Re: Falcon Marketplace Preliminary Plan (SP-17-001) Response 4

Please accept this response letter to your review comments dated July 7, 2017.

Preliminary Drainage Report (PDR) / Drainage Plans

EXISTING DRAINAGE CONDITIONS

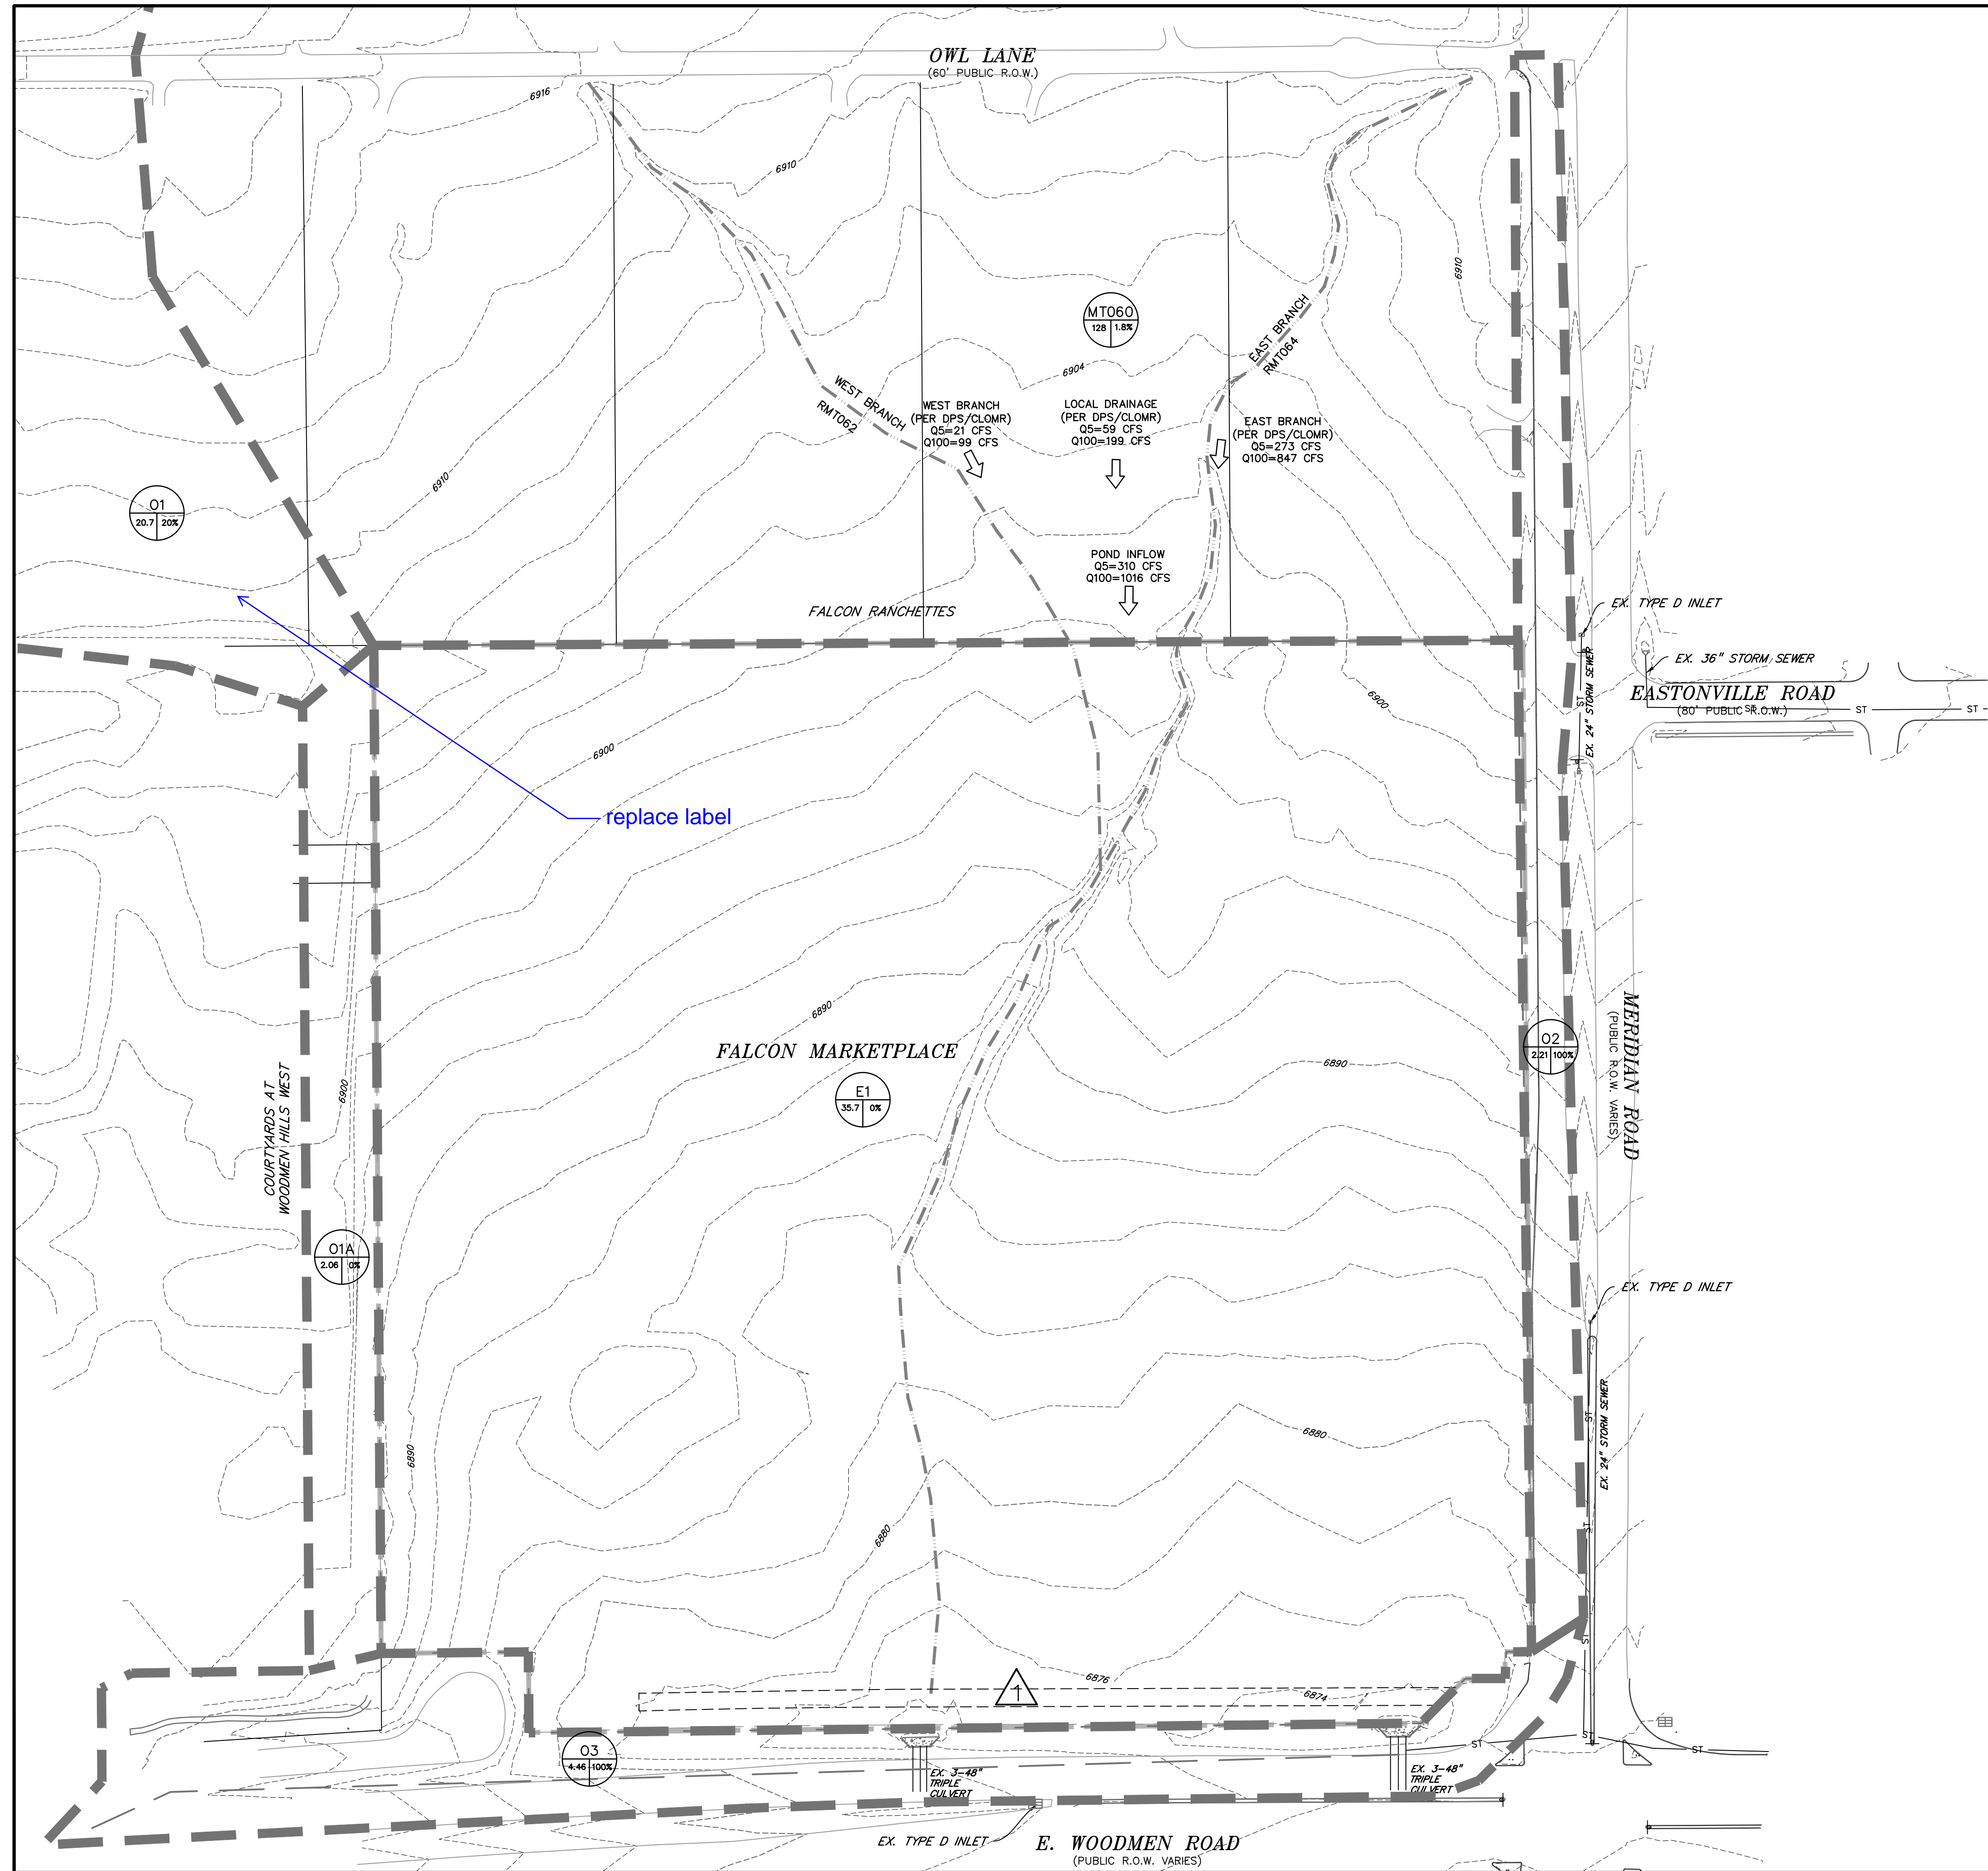
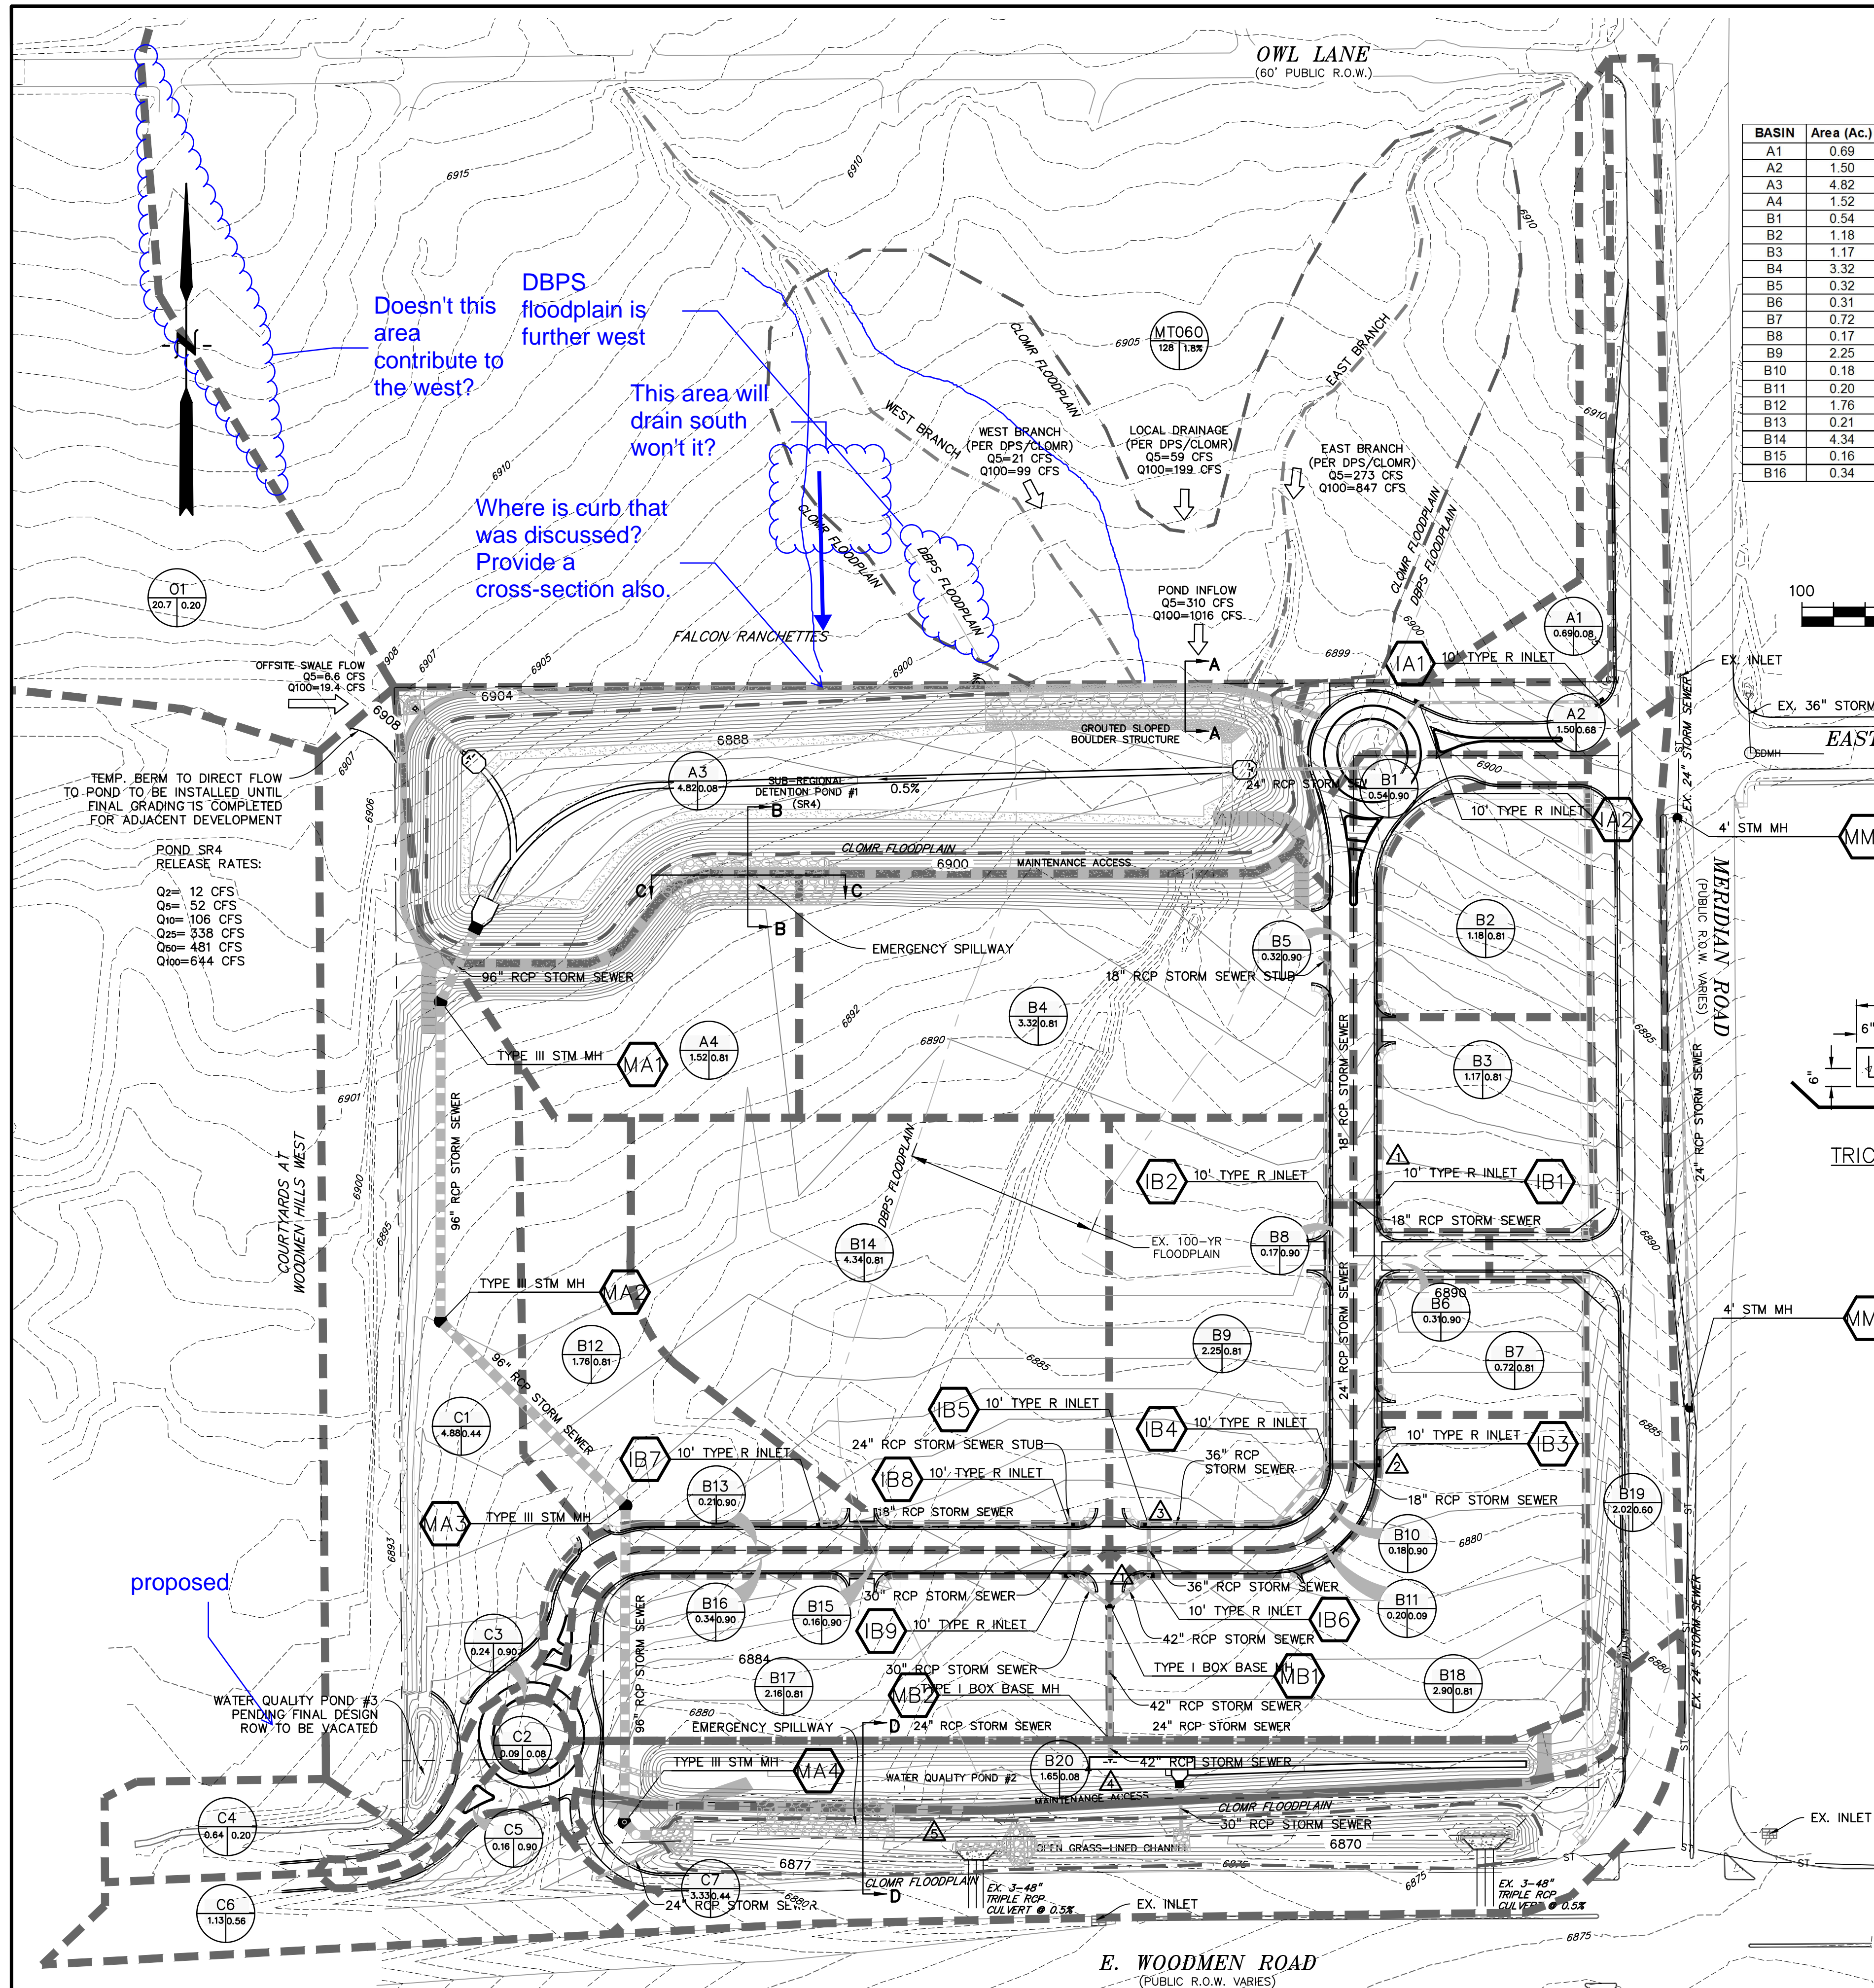
- a. Provide an Existing Conditions drainage plan. Show and label design points as appropriate for comparison to the proposed plan. Partially resolved; see redlines regarding local basins and design points. *Resolved; show existing Meridian Road storm drains at the south end as shown on Meridian Road bid set. Last portion of comment remains. Existing storm in Meridian is shown on both existing and proposed drainage plans.*

**D-1**  
 SHEET: 1 OF 1

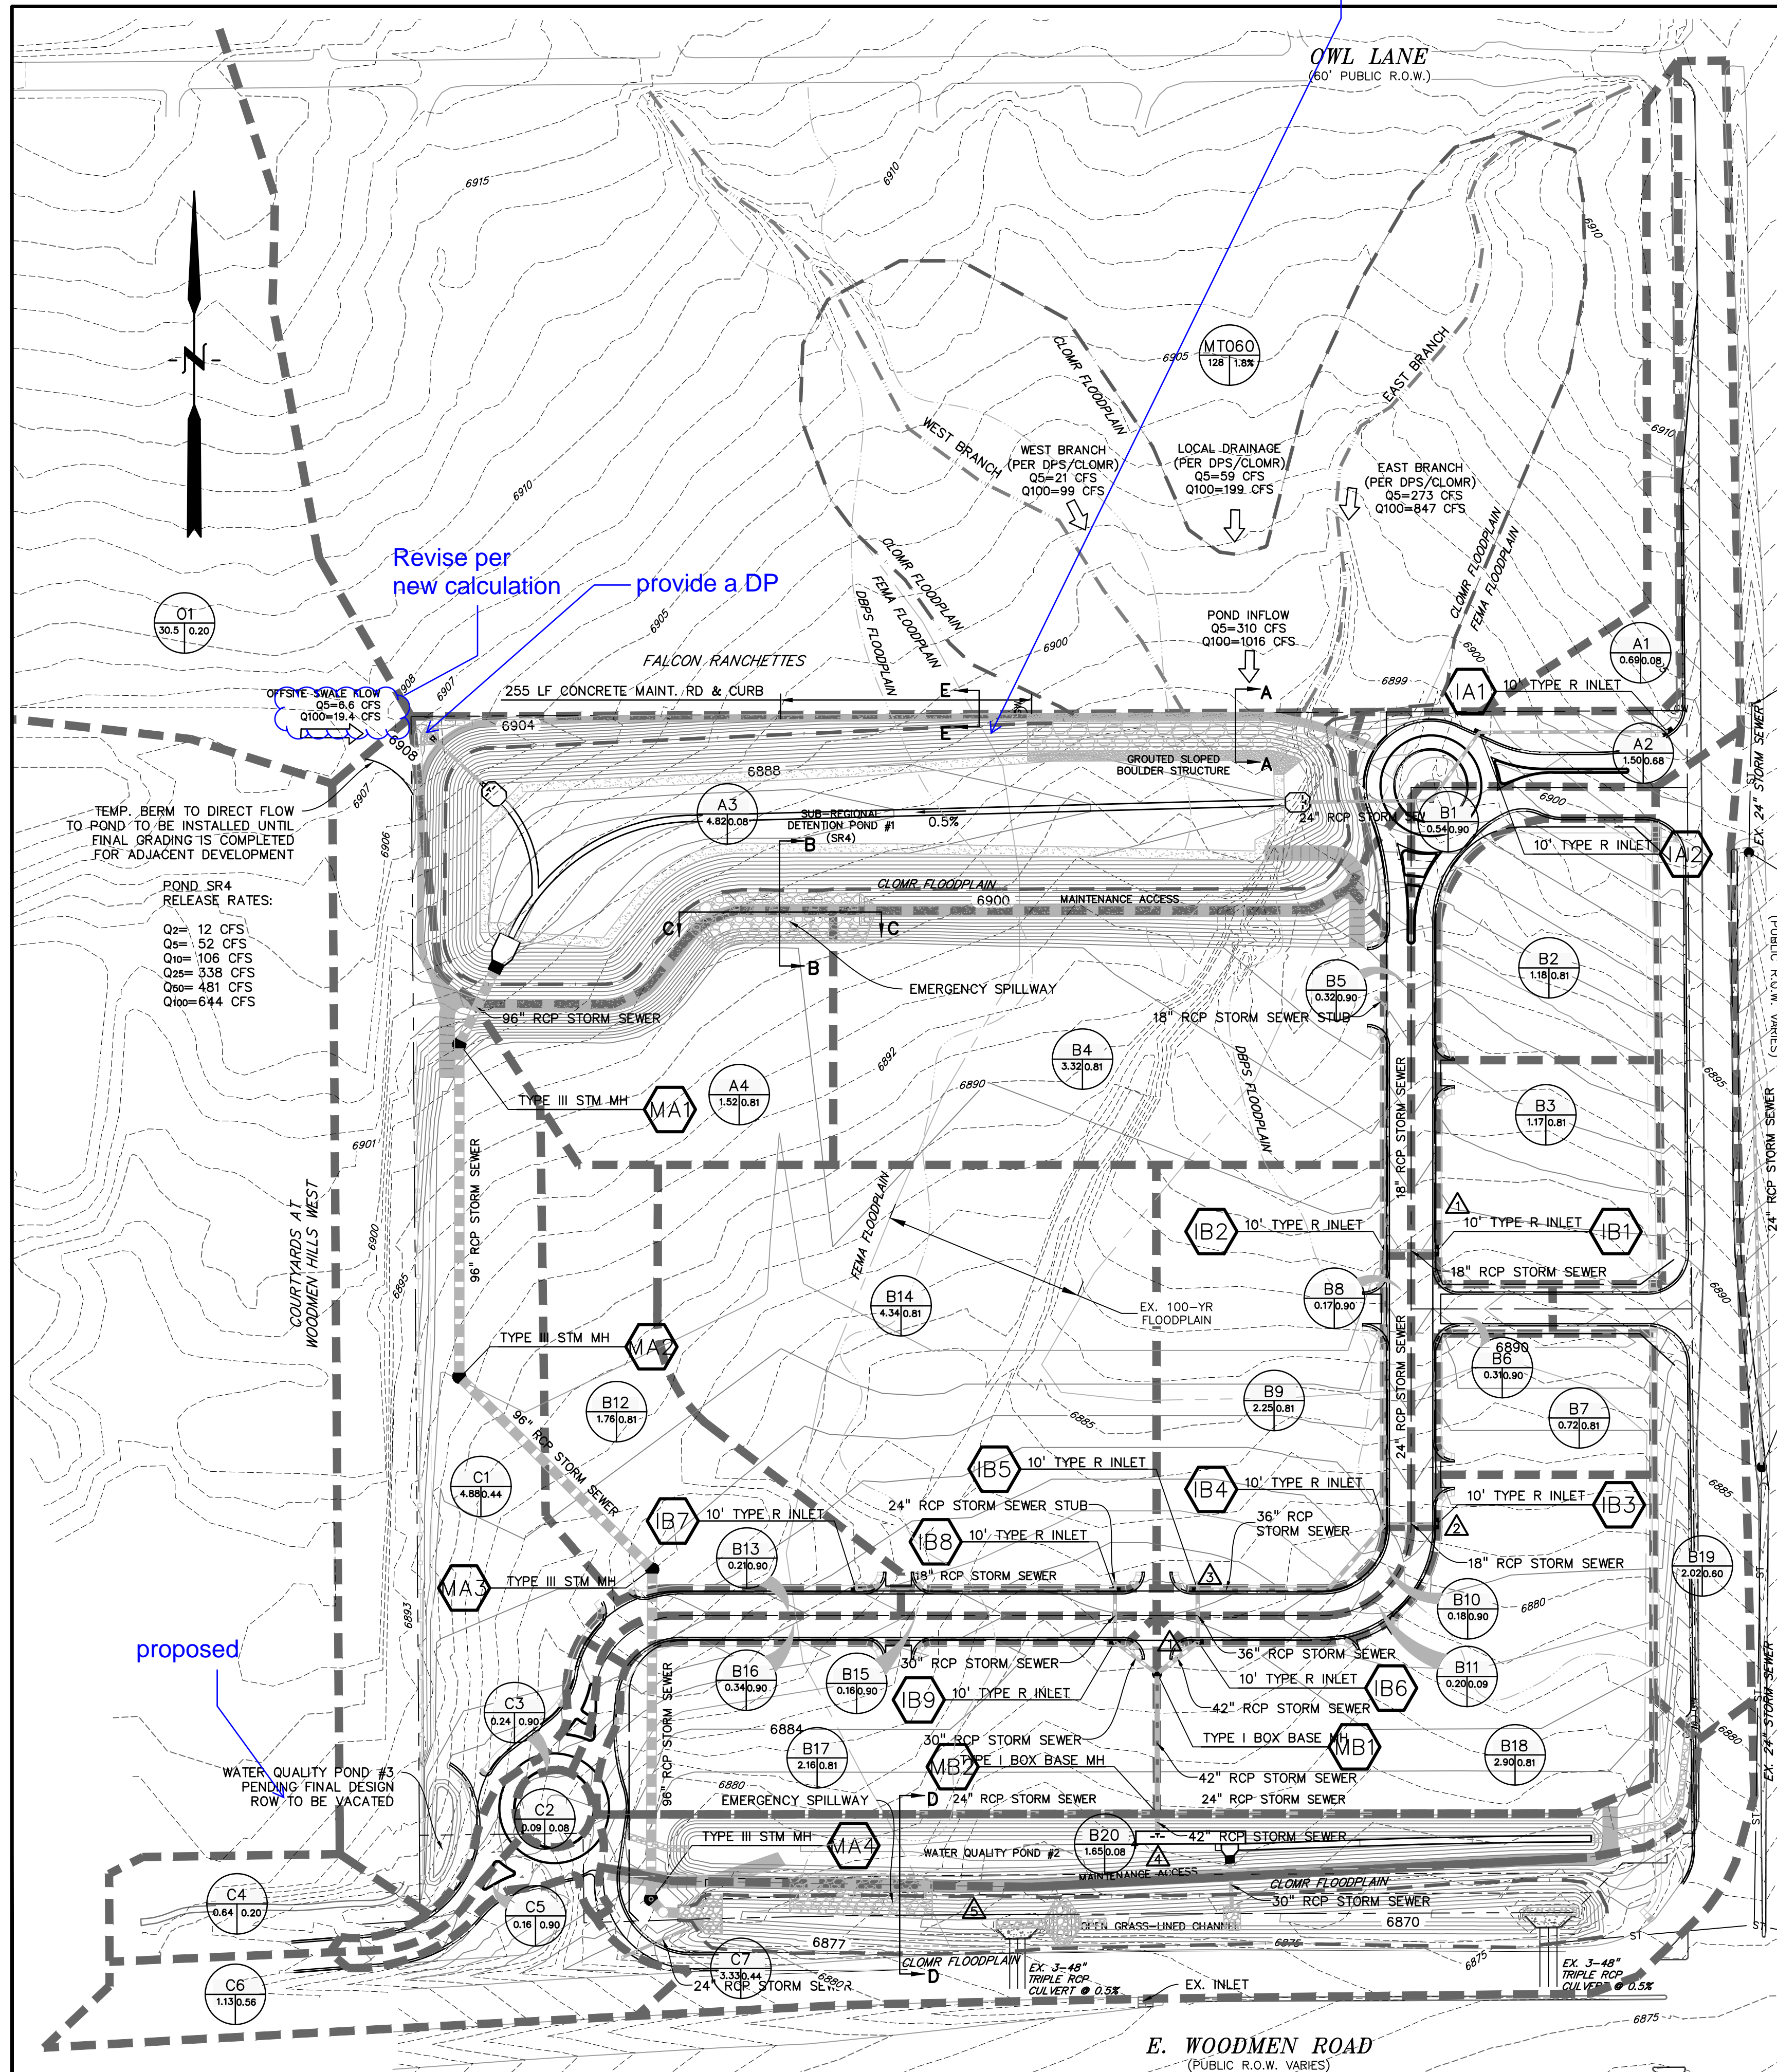
- b. Show and label all proposed maintenance access roads and easements on the Developed Conditions Plan. Partially resolved; see GEC redlines regarding this. Provide stabilized access roads along the west and north sides of the pond. *See additional redlines; due to the rundown along the north side of the pond, pond bottom stabilization is required which could be incorporated into an access road design through that area. Comment remains. Stabilization of the pond bottom has been incorporated into the design.*

- c. Provide a design point summary of 5- and 100-year flow rates at all surface and pipe design points on both the existing and proposed plans. Partially resolved; address per local basin and DP redlines. *Comment remains; see redlines regarding flows from the north. Comment remains. Offsite flow note added to proposed plan.*
